4.21.2021
Koke Consulting Group Inc
Permit #: 2012-199 4225 89th Ave SE

Please note the following changes have been made and bubbled on the plans to the above listed project per your requests:

**SECTION AA**

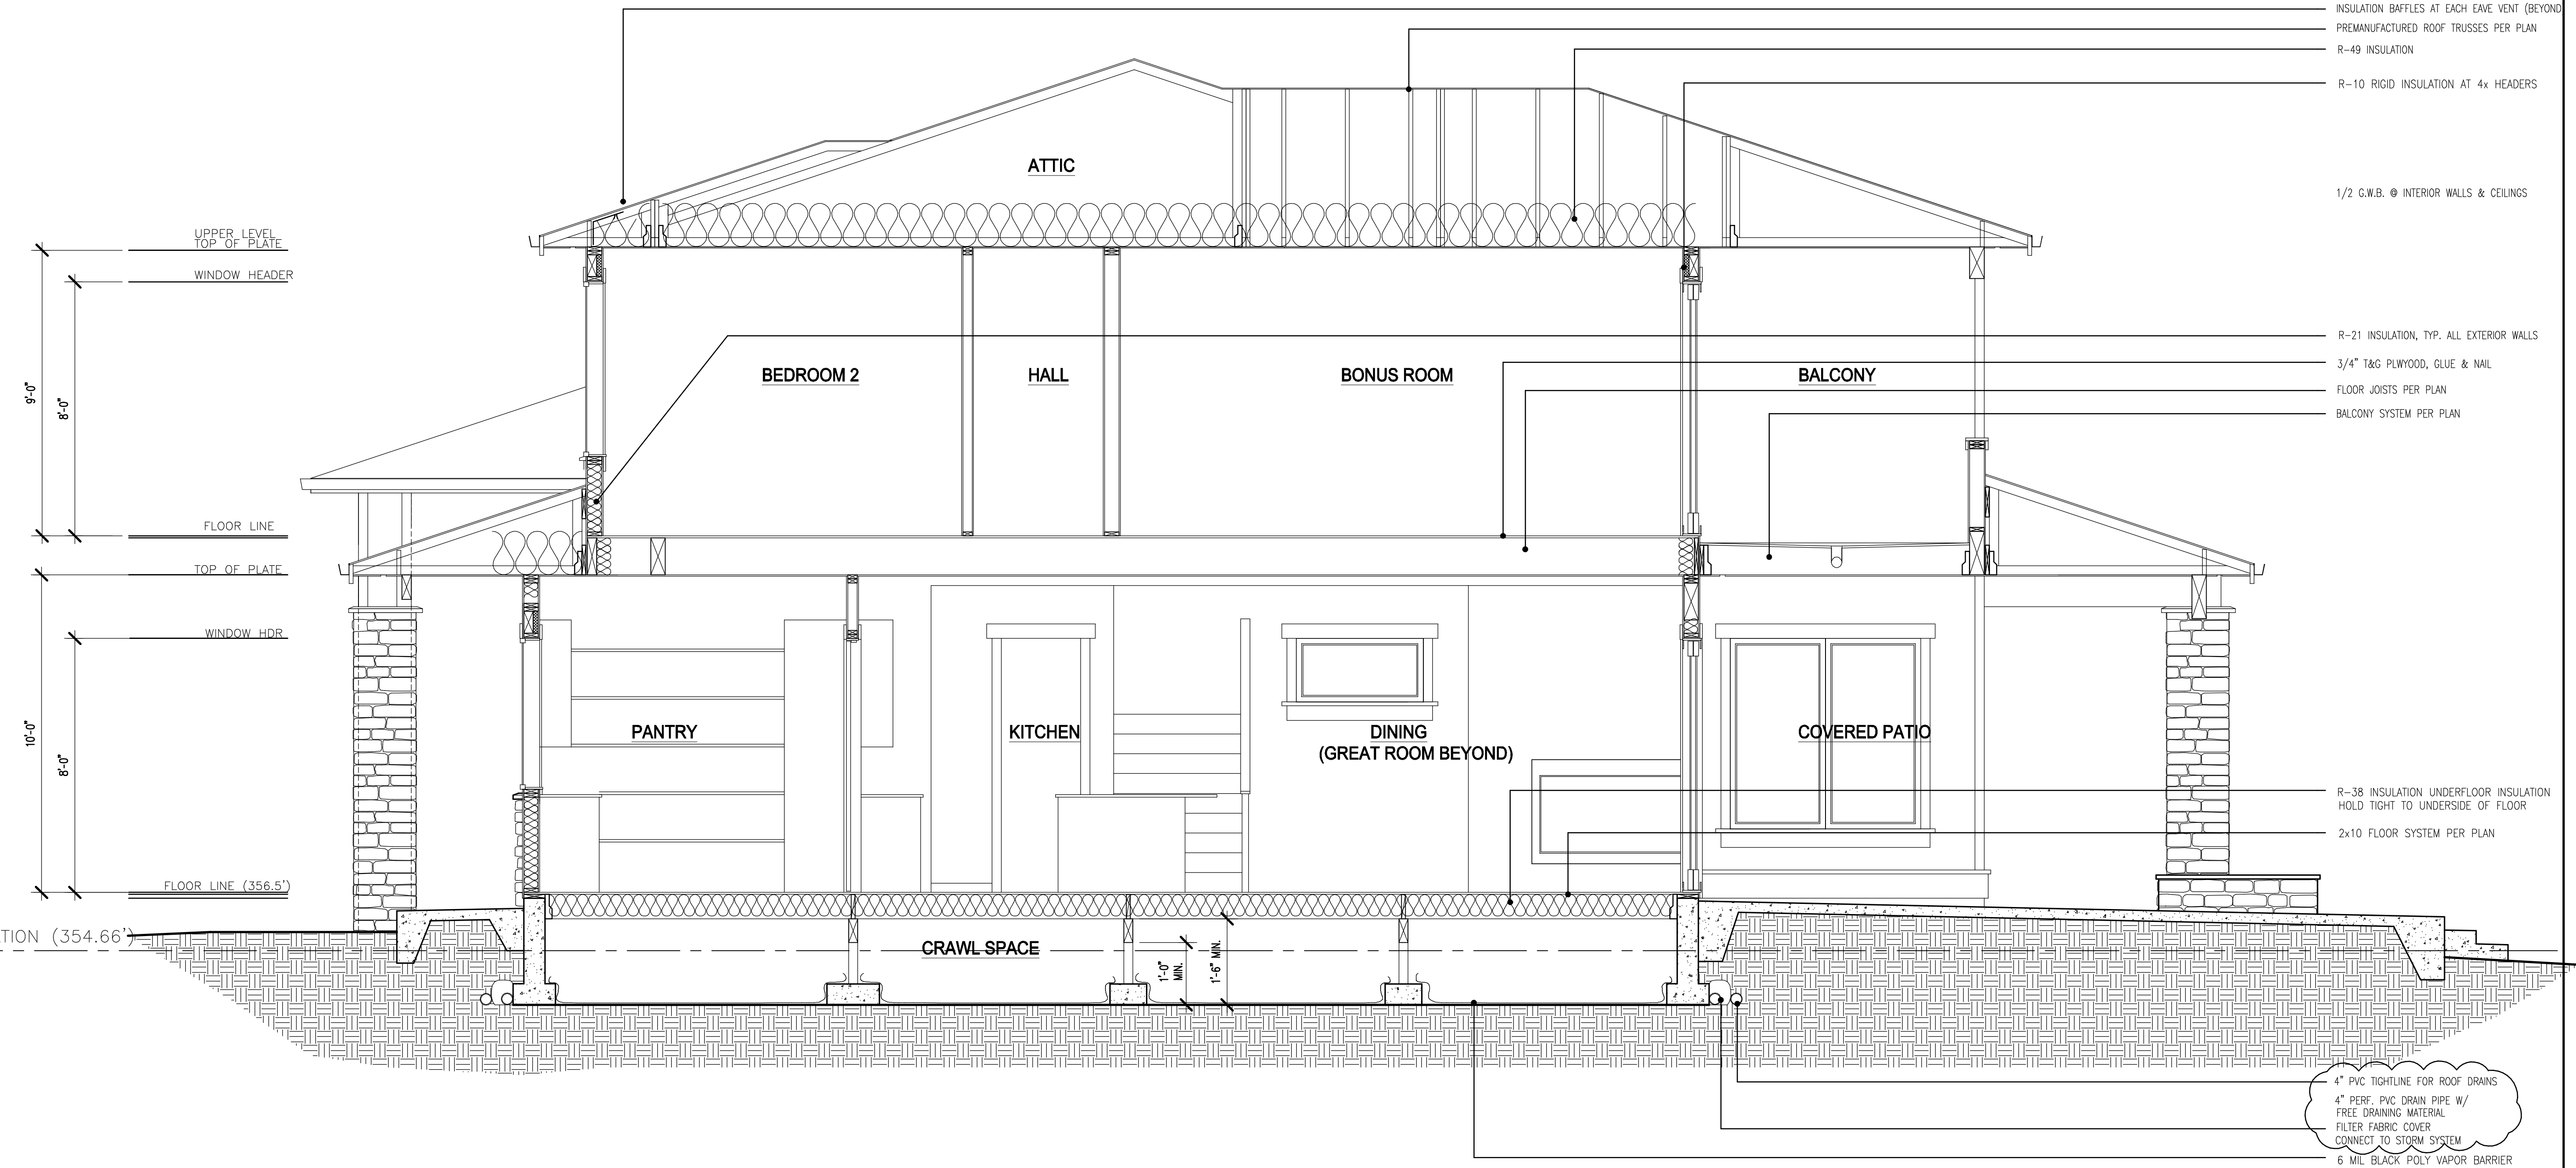
7. The building section on page A9 previously detailed the footing drains, but has been modified to show the roof drain tight-lines.
 8. Attic access is now shown on the low roof framing plan Sheet A5 at the den.
-
